*Lancashire Gardens Trust*  
*Conservation & Planning Group*

**Planning Application No: 3/2016/0167/FUL**  
**Formation of 2No Tennis courts with seasonal polythene inflatable dome, perimeter fence and floodlighting; reconfiguration of car park and formation of two coach laybys; Stonyhurst College, Avenue Road, Hurst Green, Clitheroe.**  
**TGT Reference: E15/01498**

client: stonyhurst college
project: new tennis court facilities
stonyhurst college
sheet: proposed site plan

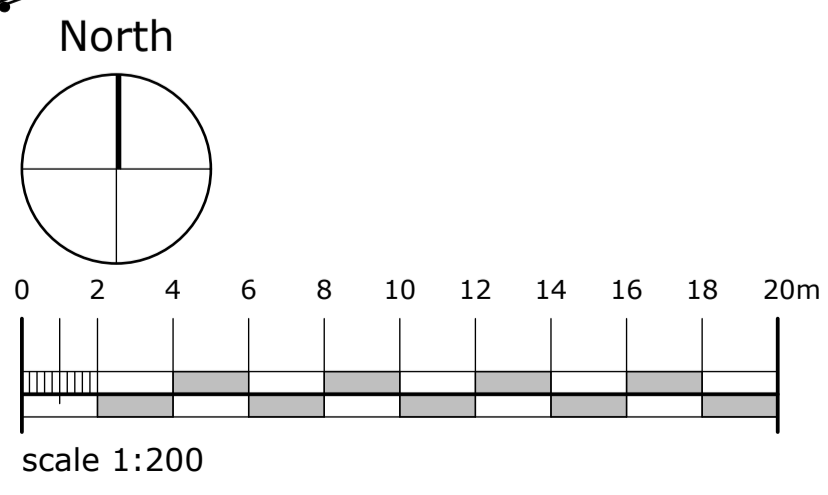
The LGT supports the College's current proposals for enhancing the facilities at the College. We note that the application site lies within the boundary of the Registered Park and Garden, and as far as we are aware, no heritage features are affected by the proposals, and some of the site is already in use as car park. However we would recommend augmenting the landscape proposals indicated on the application drawings by the addition of hedge planting along the main driveway to supplement the new trees proposed.
